Our ref: TR010035

**A585 Windy Harbour to Skippool Improvement Scheme
Reference TR010035
Non-Material Design Changes**

Following submission of the application and engagement with certain interested parties and landowners, the Applicant seeks to make certain non-material changes to its application. The changes are as follows:

Drawing Title	Drawing Number	Revision
Crown Land Plan – Regulation 5(2)(n) – Sheet 1 of 1	HE548643-ARC-HGN- SZ_ZZ_000-DR-D-3088	2

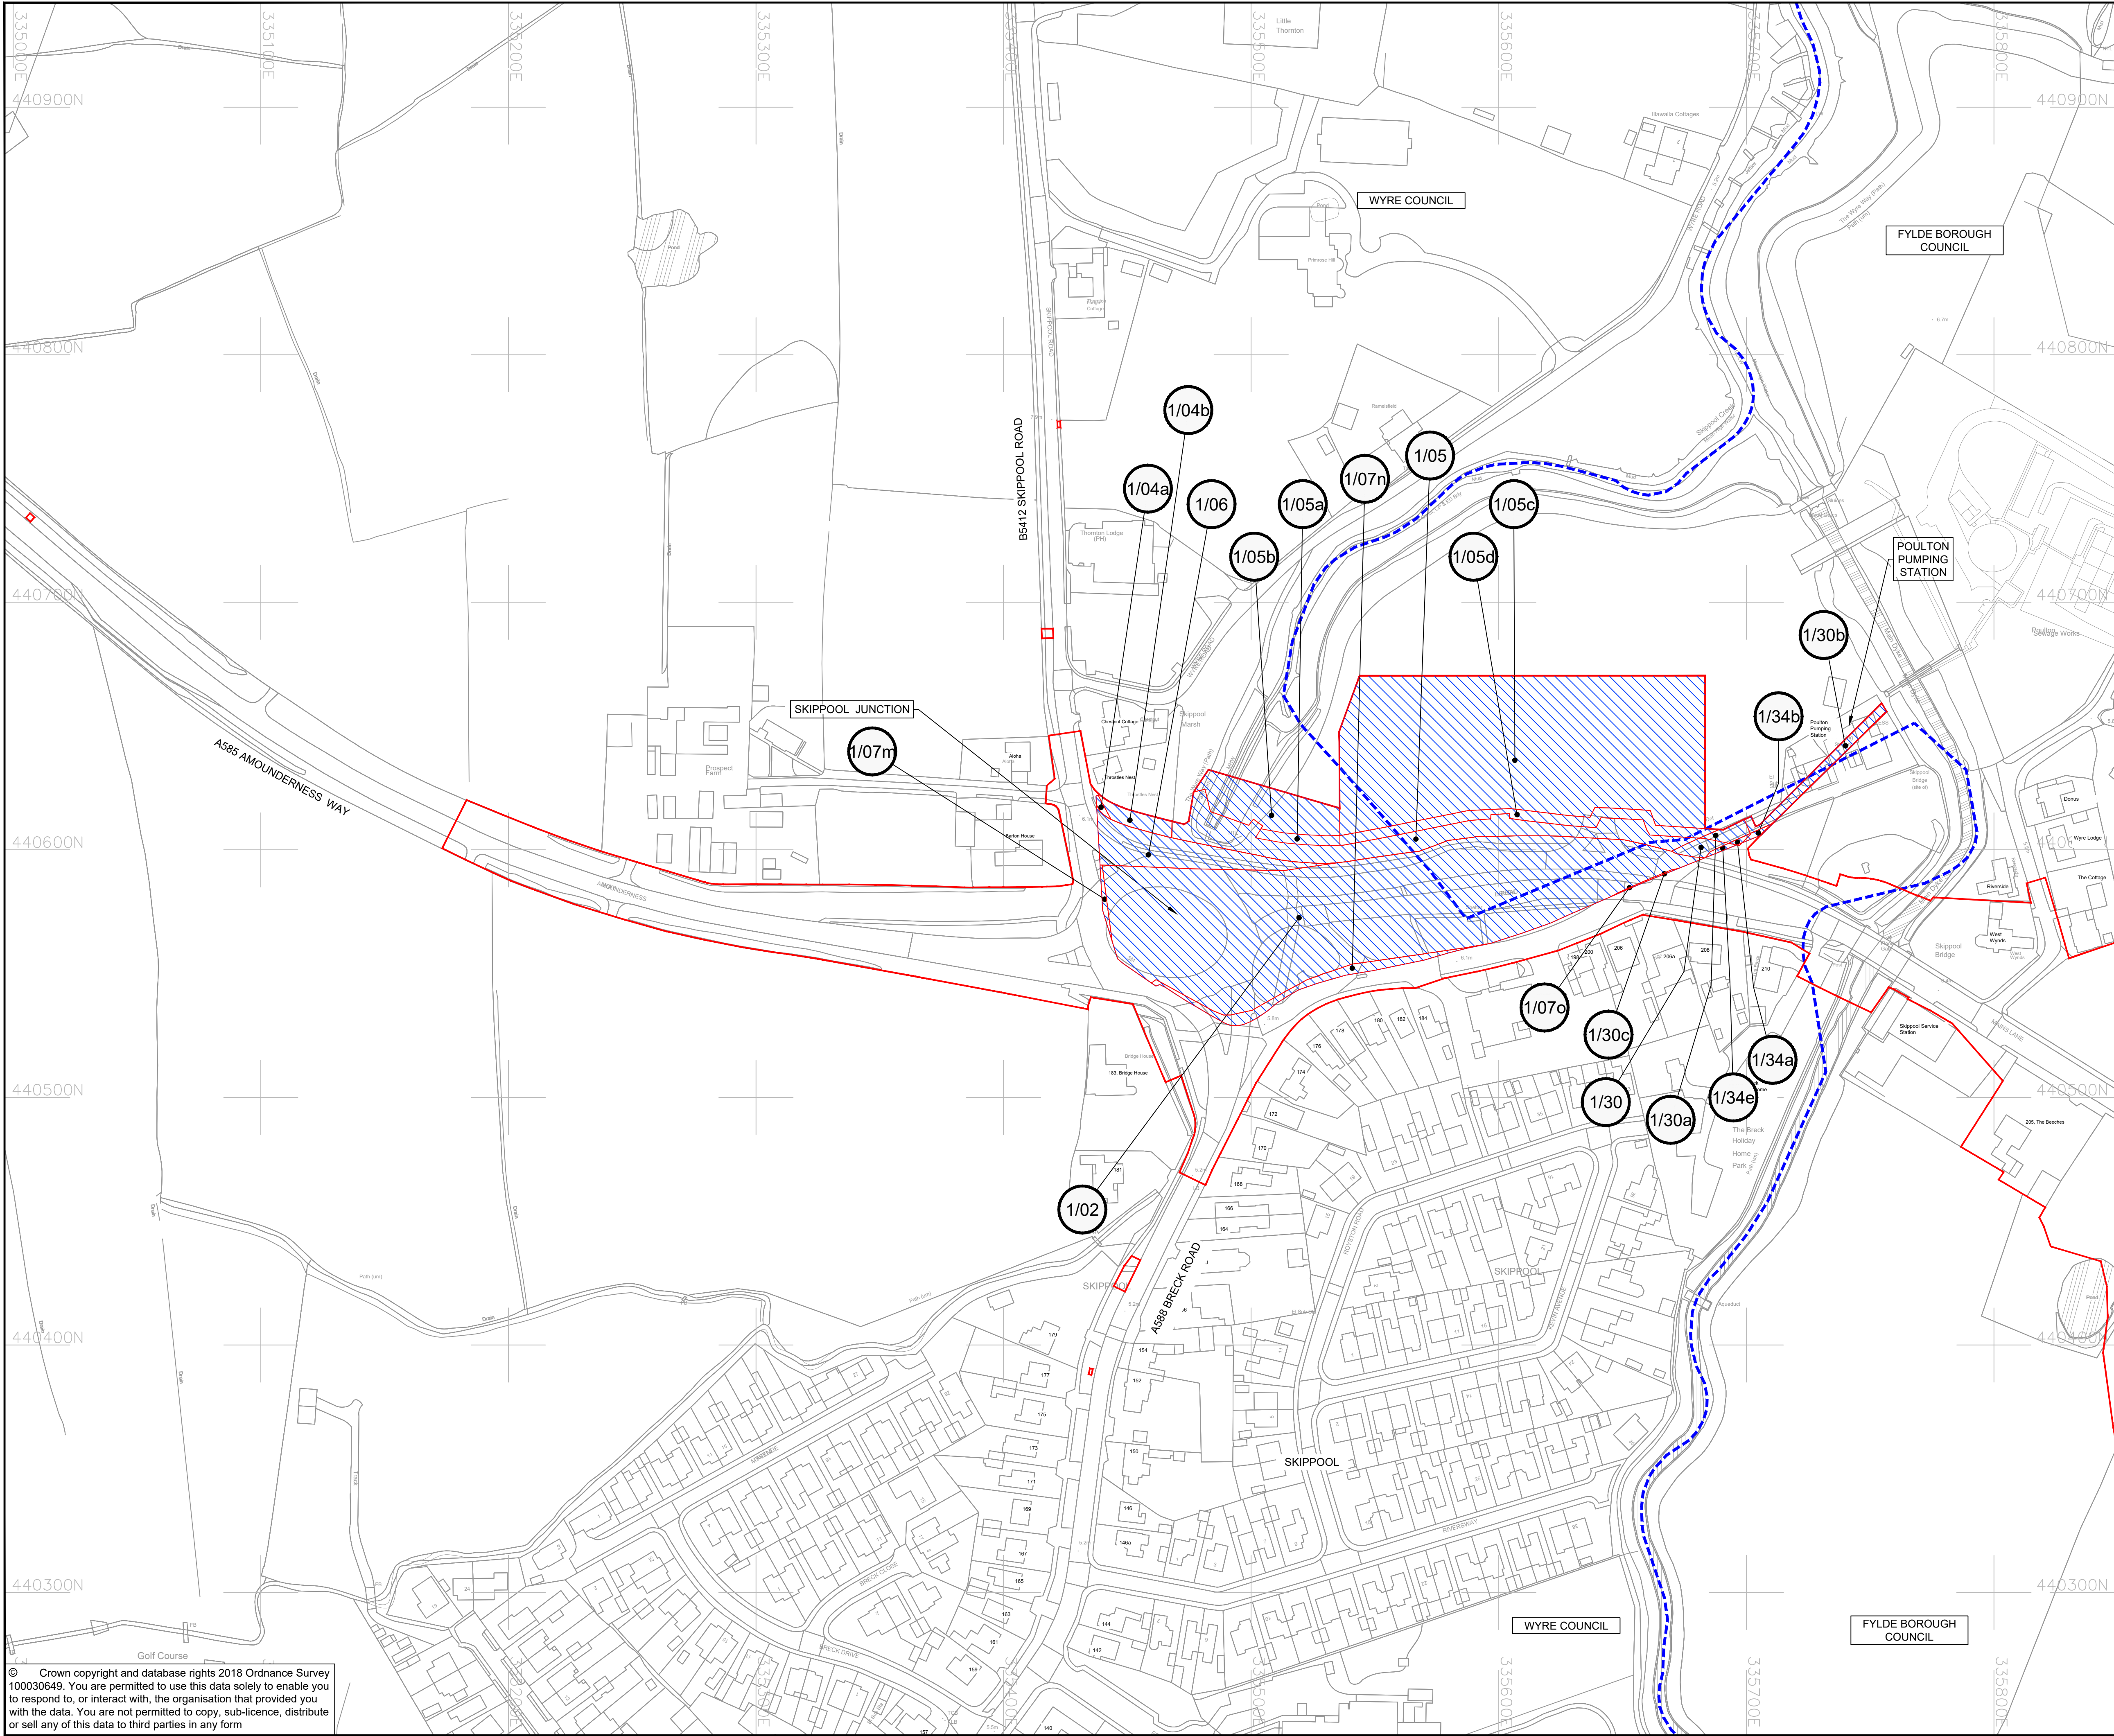
Construction of a dwarf wall and widening of the northern footway/cycleway from Skippool Road. In consequence of this proposed change, it will also be necessary to remove a length of hedgerow and plant a new hedgerow to 6 metres north of the existing hedgerow. The proposed changes are shown on the enclosed drawing (HE548643-ARC-HGN-SZ_ZZ_000-DR-4035).

The proposed change will require small adjustments to the land required for the Scheme as follows:

| Throstles Nest, Skippool Road and land north of Breck Road | Duchy of Lancaster | 1/04b | Increased by 52 sqm |
| | | 1/05 | Increased by 69 sqm |
| | | 1/05a | Decreased by 4 sqm |
| | | 1/05b | Decreased by 33 sqm |
